Current Zoning: N1-C (single family residential)
Proposed Zoning: UR-2(CD) (urban residential, conditional)

Approximately 1.64 acres located along the east side of Catalina Avenue, south of West 28th Street, and north of West 26th Street.

The petition proposes to allow up to 26 attached residential units on parcels that are currently vacant.

SITE PLAN

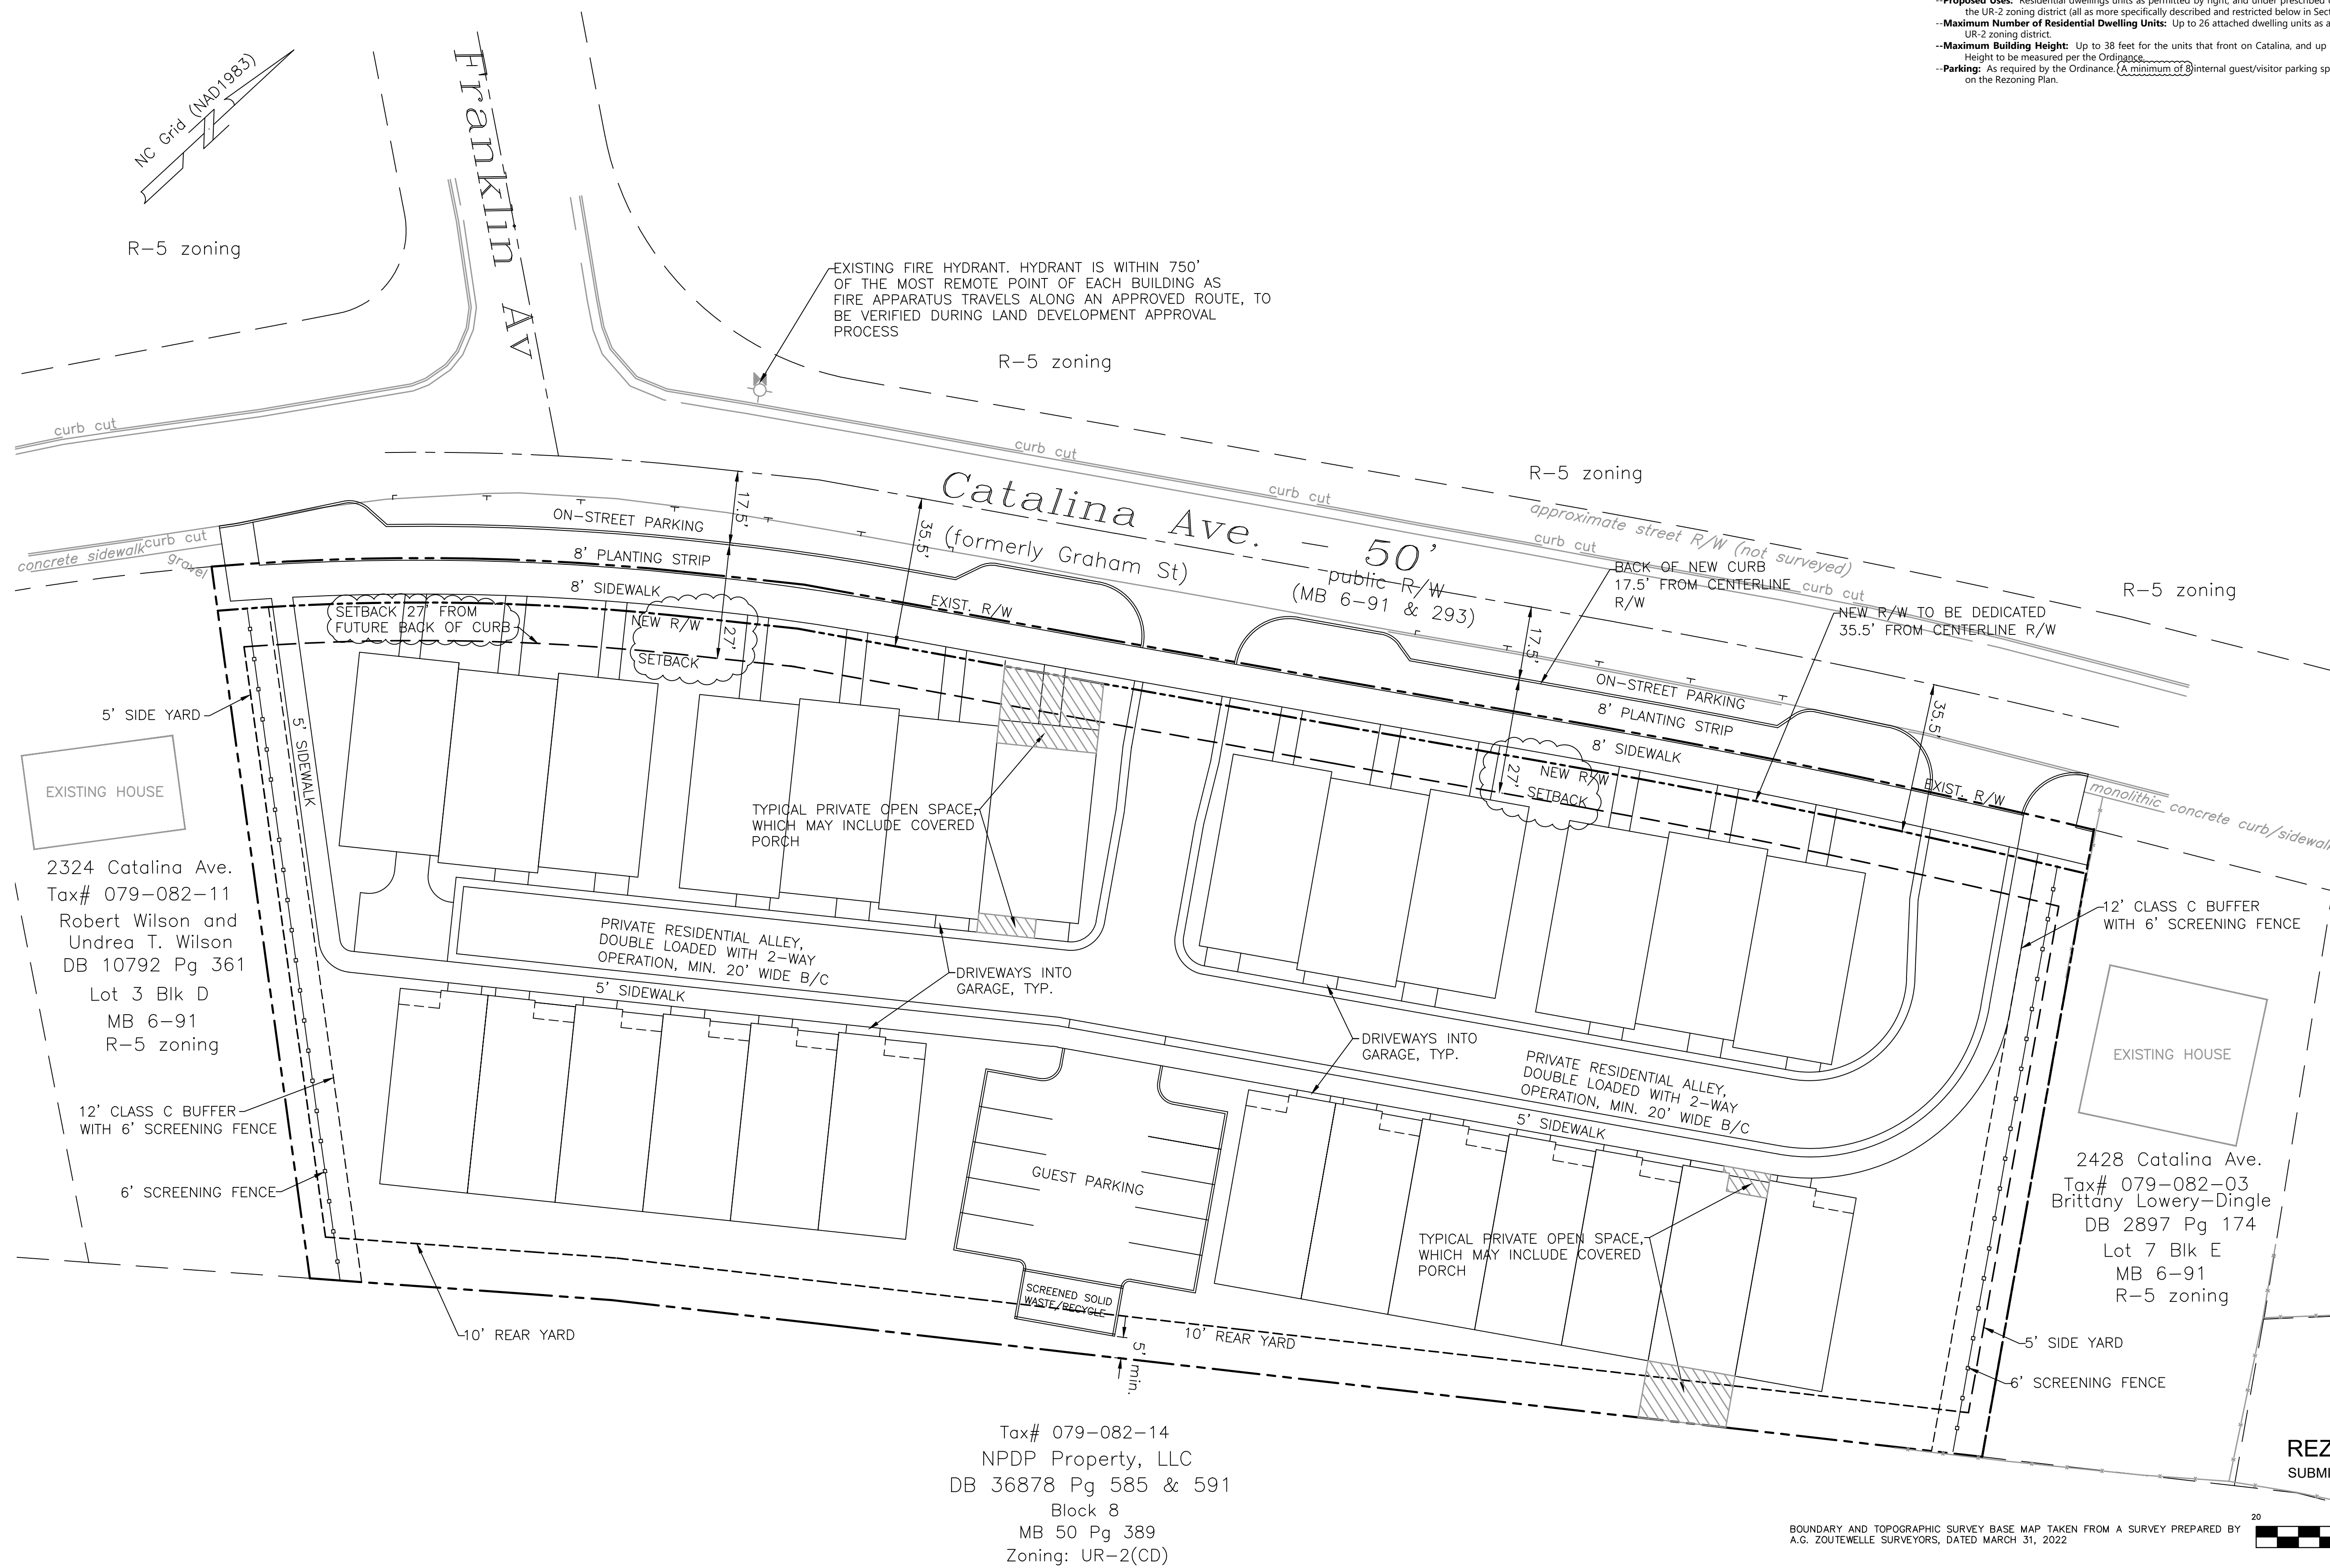
1. ~~Revise the site plan so that no structures are located in the setback.~~ **Addressed**
 2. ~~Relocate the proposed screened solid waste and recycling area so that it is not within the rear yard or 5' of the property to the rear.~~ **Addressed**
-
